2205-074 – InTake2

# Leung Residence

## Intake Screening Response

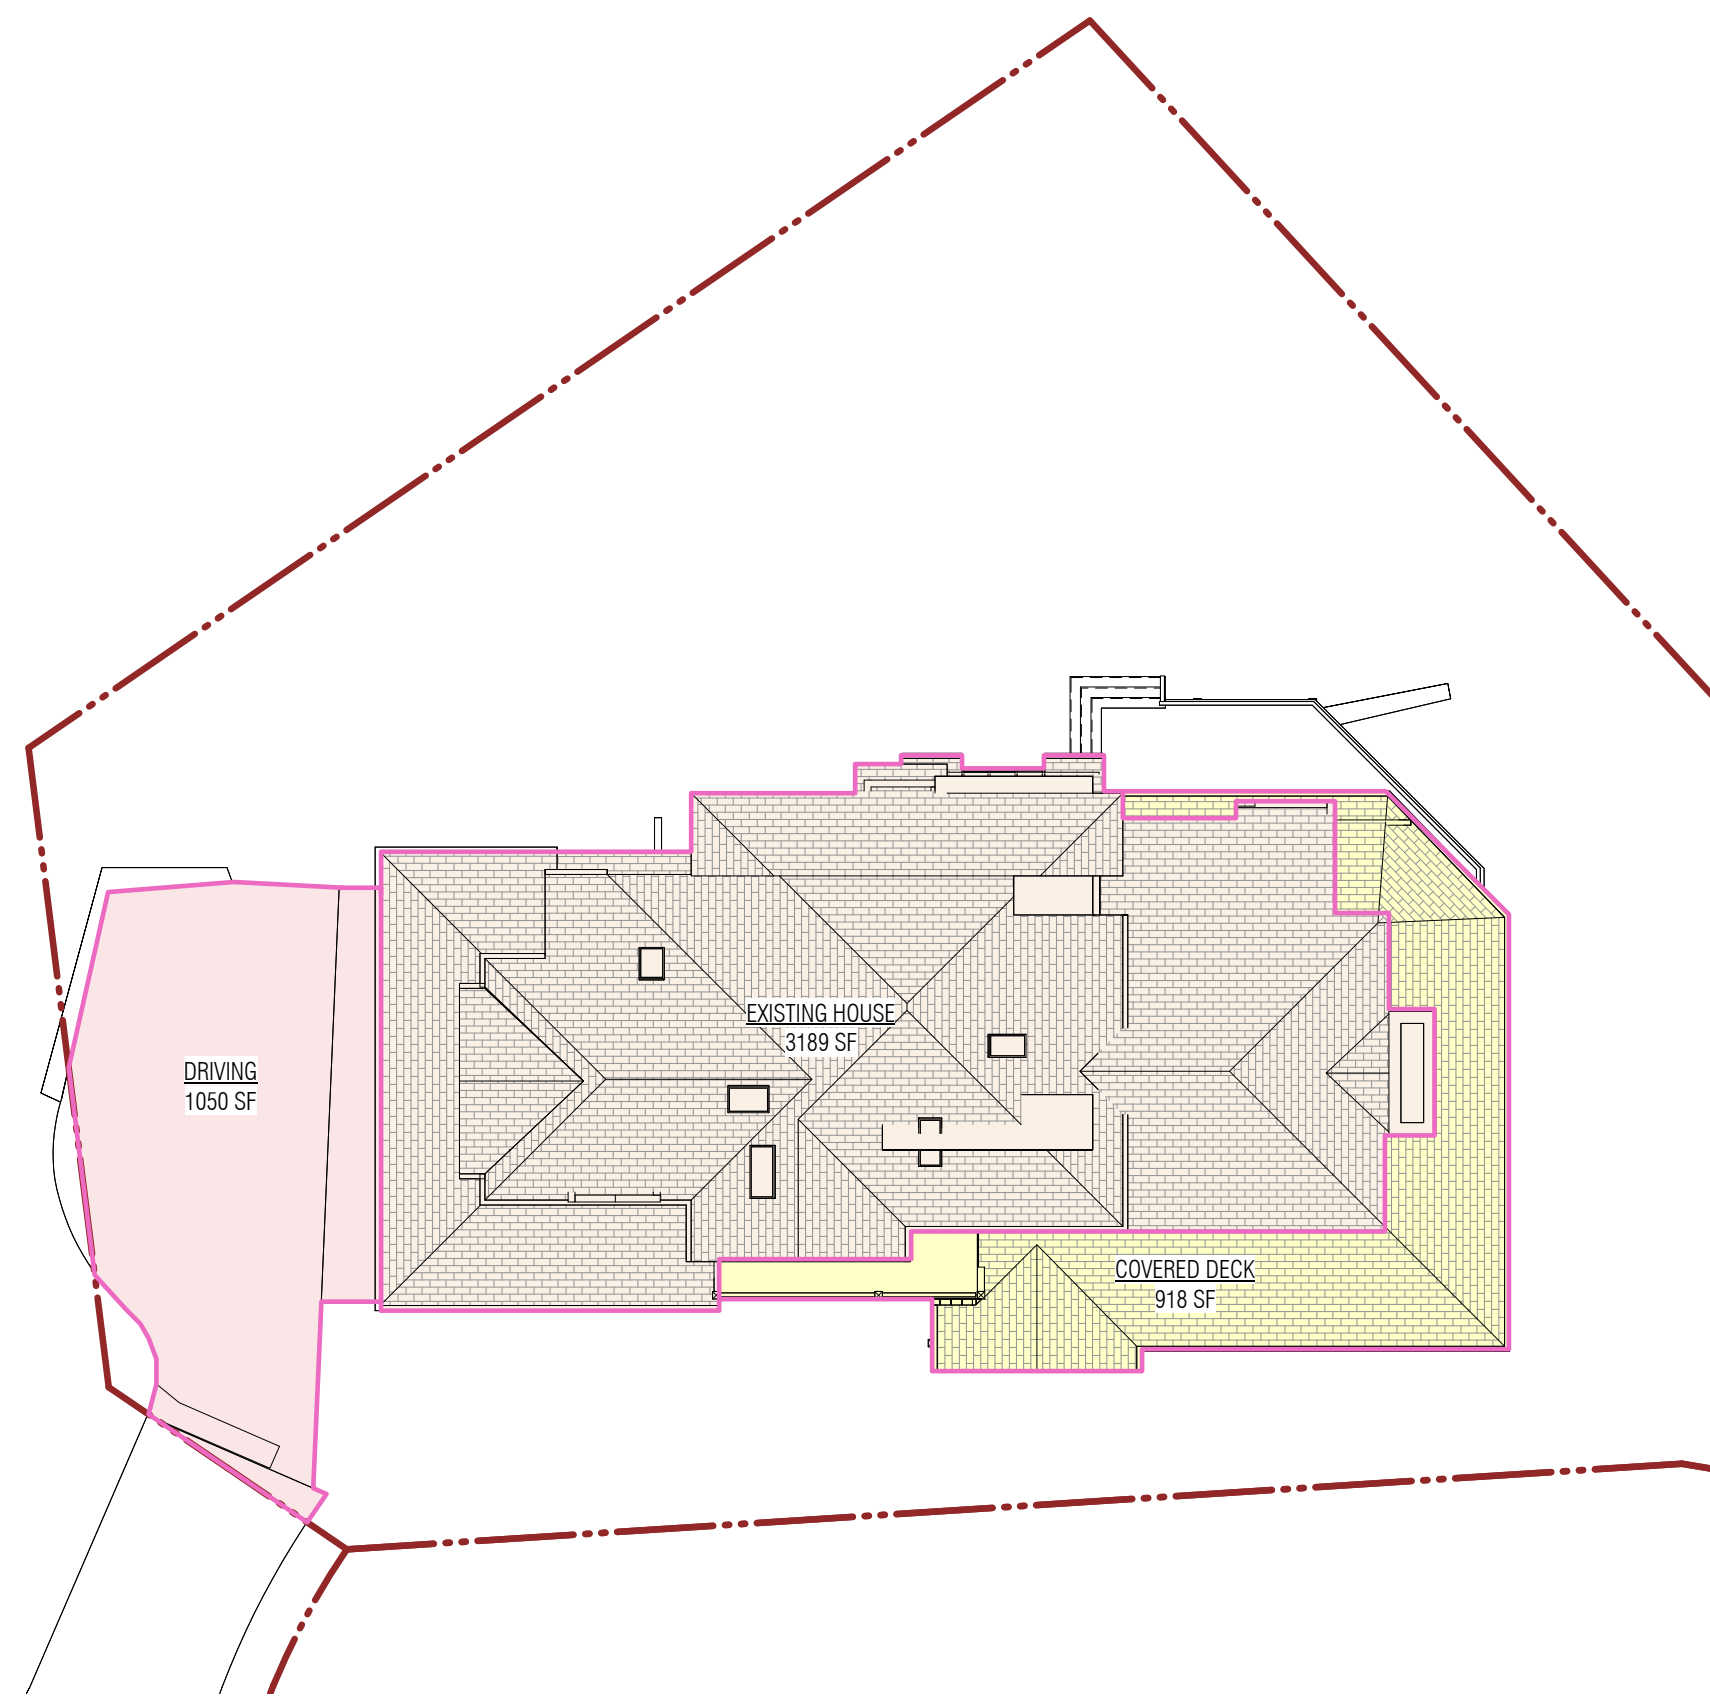
*Provide lot coverage, hardscape & GFA calculations*

Response: See Sheet G1.03 Zoning Code – Site Diagrams for updated lot Coverage and Hardscape Calculations. See sheet G1.02 for GFA calculations.

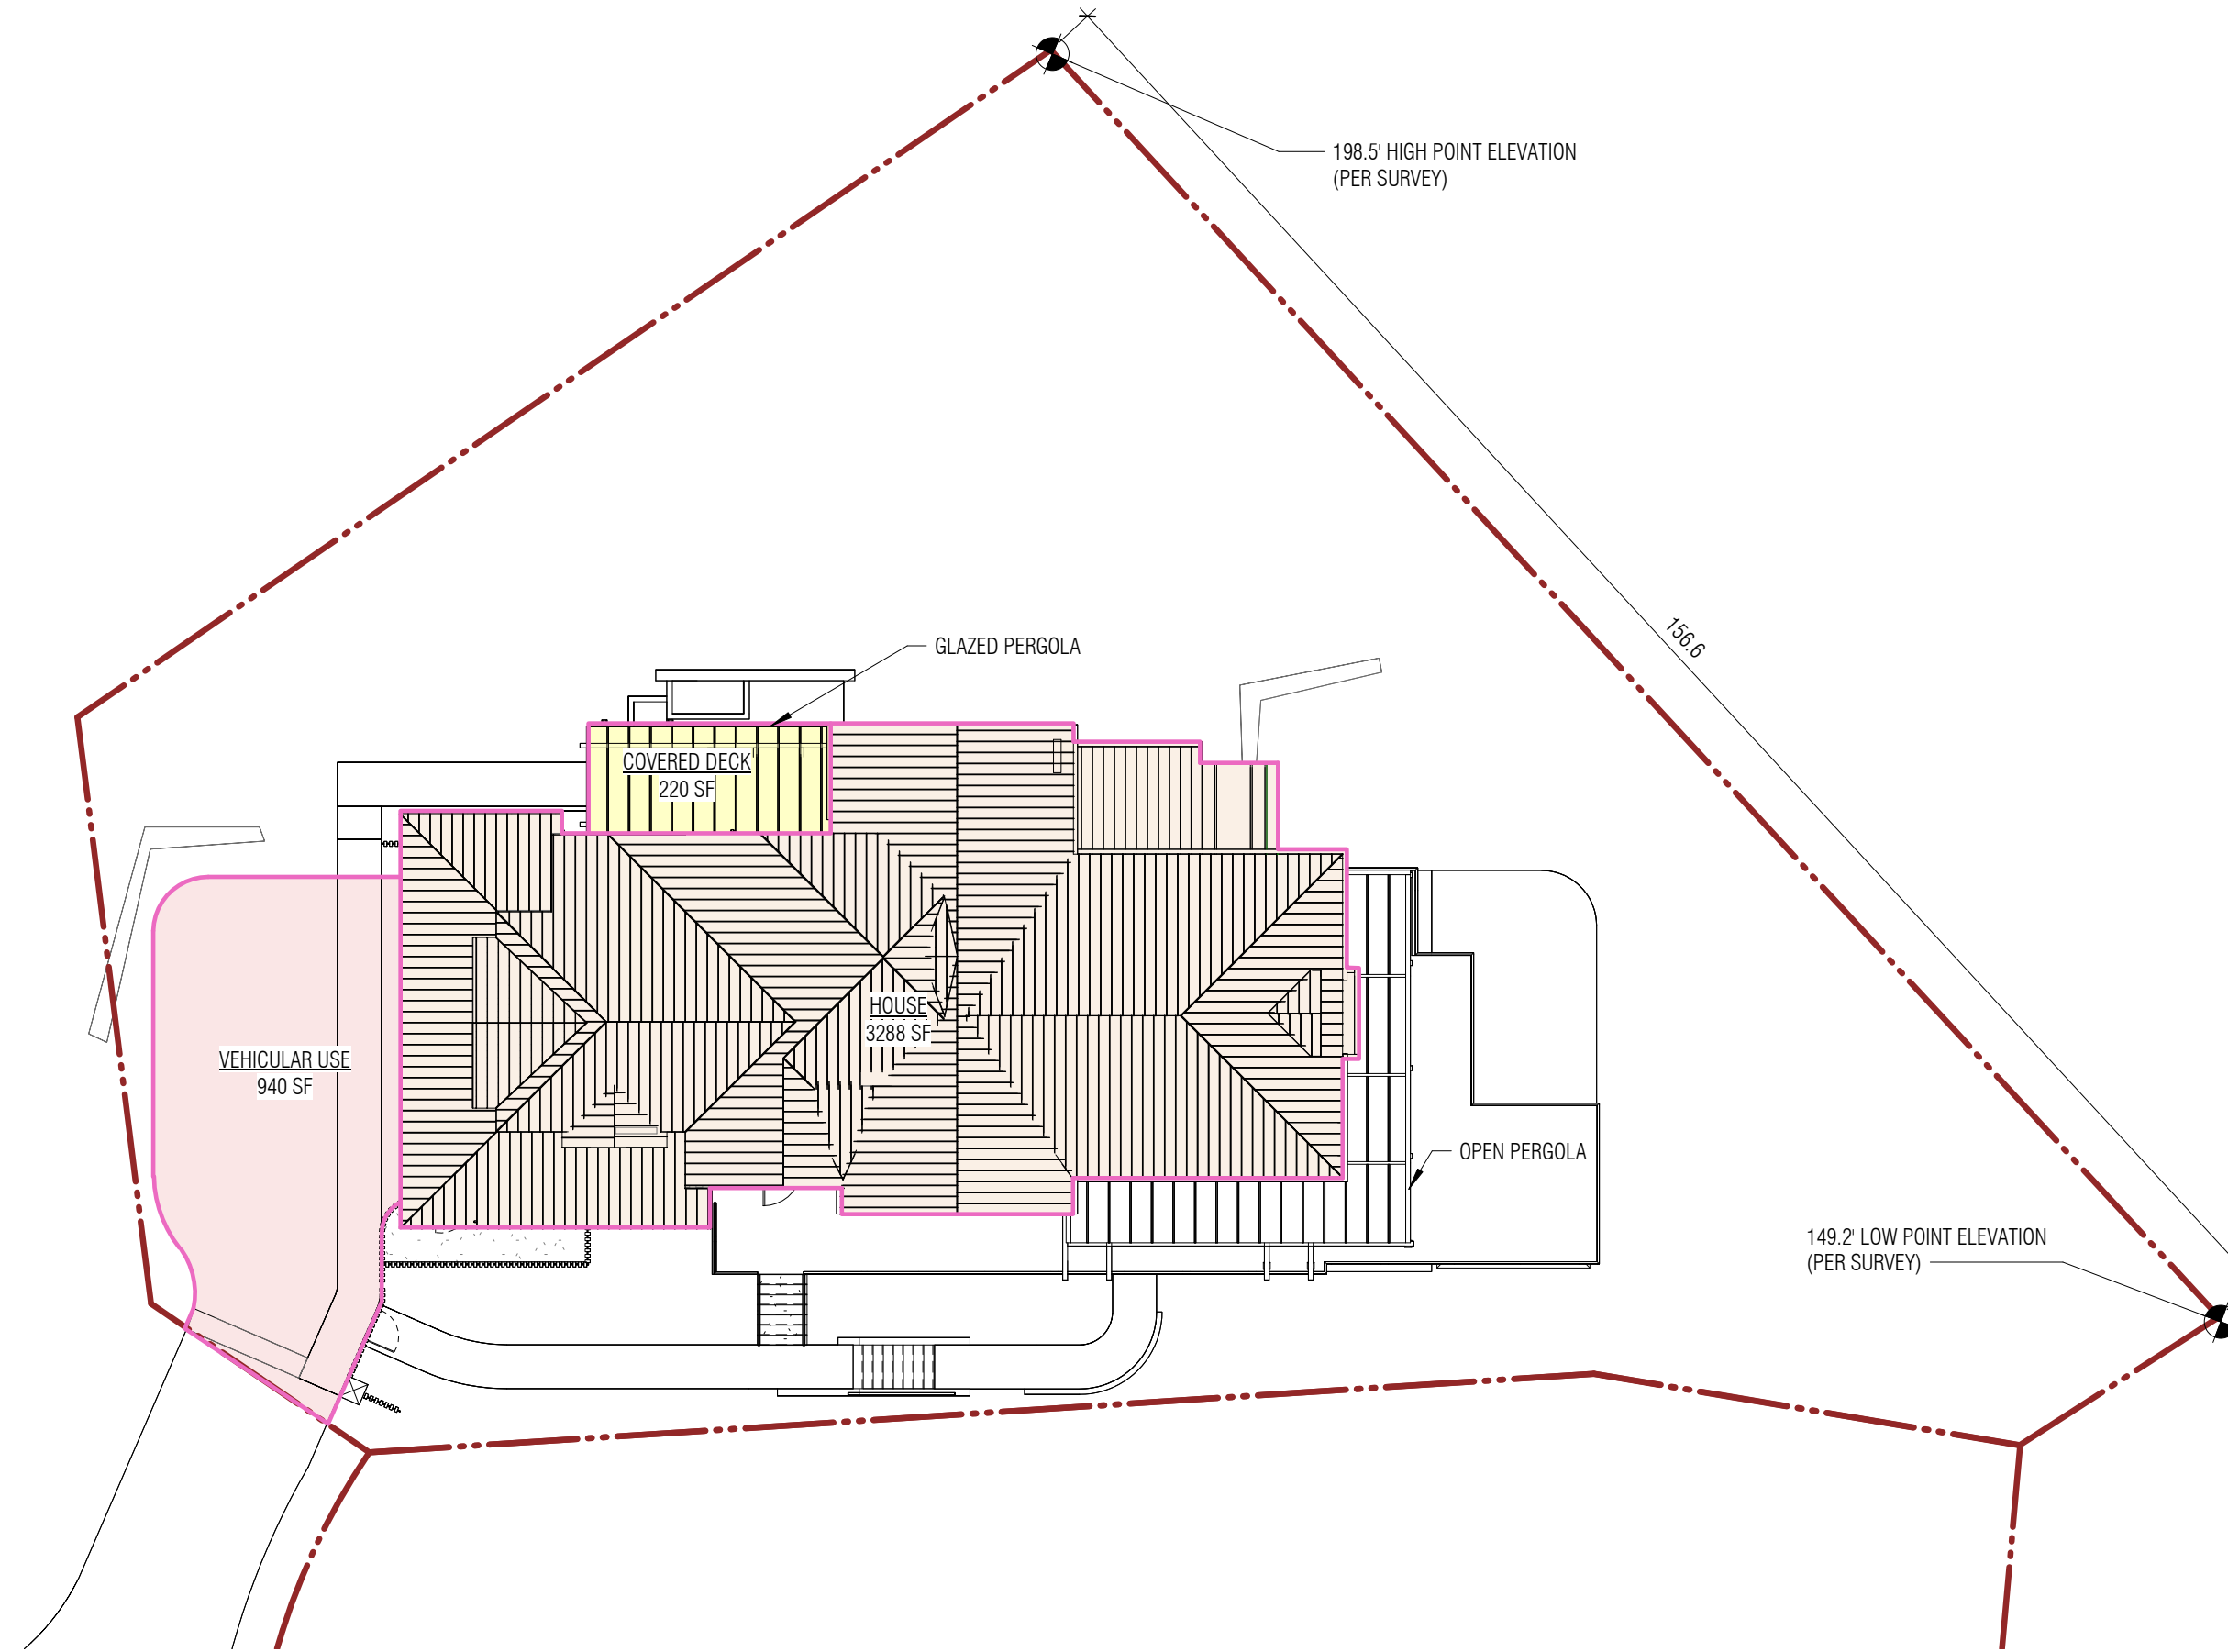
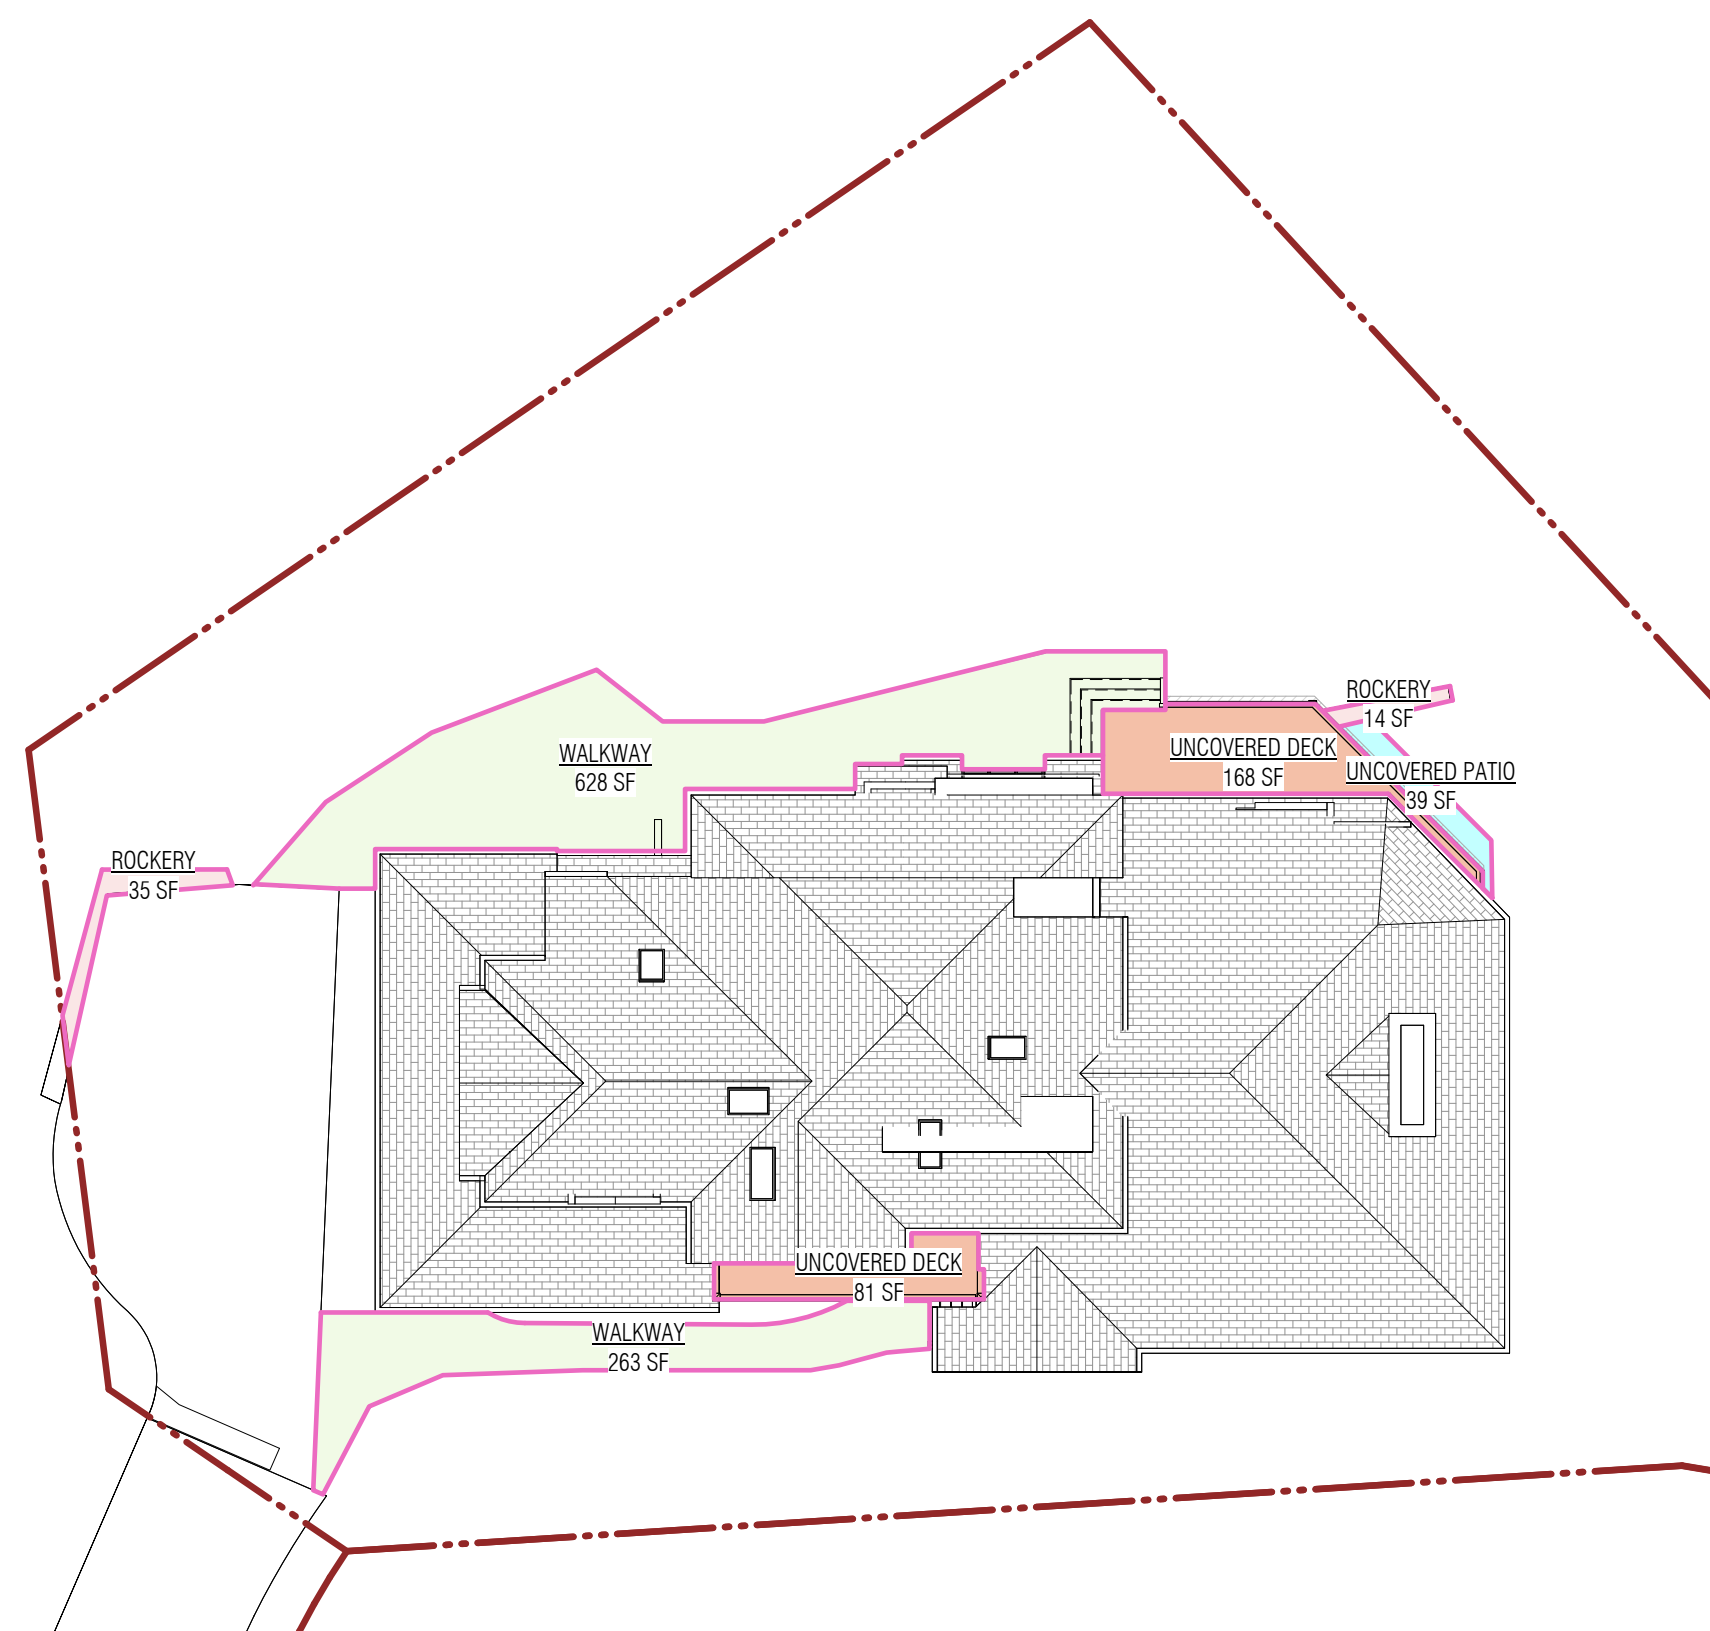
*The proposed glazed pergola is considered roof area and must be included in lot coverage calculations. This would likely cause the 30% lot coverage limit to be exceeded. If you are proposing to remove existing lot coverage to allow new lot coverage as allowed under MICC 19.01.050(F)(3)(b), please demonstrate how the requirements of MICC 19.01.050(F)(3)(b) are being met.*

*The proposed hardscape exceeds the 9% limit set forth by MICC 19.02.020(F)(3)(b)(i). Please revise the proposed hardscape to comply this this limit.*

*It also appears that the synthetic turf to the northeast of the house was not included in the hardscape calculations. Synthetic turf is included in the definition of hardscape and must be included in hardscape calculations.*

Response: Proposed south glazed pergola has been updated to be an open trellis design pervious to the decking below. Hardscape Calculations and Lot Coverage Calculations on Sheet G1.03 have been updated to reflect this. All plans have been revised to reflect the open pergola design and notations. See sheet A1.01 for building setbacks and location of pergola, no portion of the proposed pergolas open or glazed extend into the building setbacks.

Response: Please see sheet G1.03 for updated Hardscape Calculations and sheet L1.21 for updated Landscape Plan. The site plan has been updated so that the hardscape now falls under the 9% max limit per MICC 19.02.020(F)(3)(b)(i). The synthetic turf material has been revised to natural turf and soil management plan (sheet C2.1) and Drainage Report (sheet 34 and 35) have been updated to reflect that.
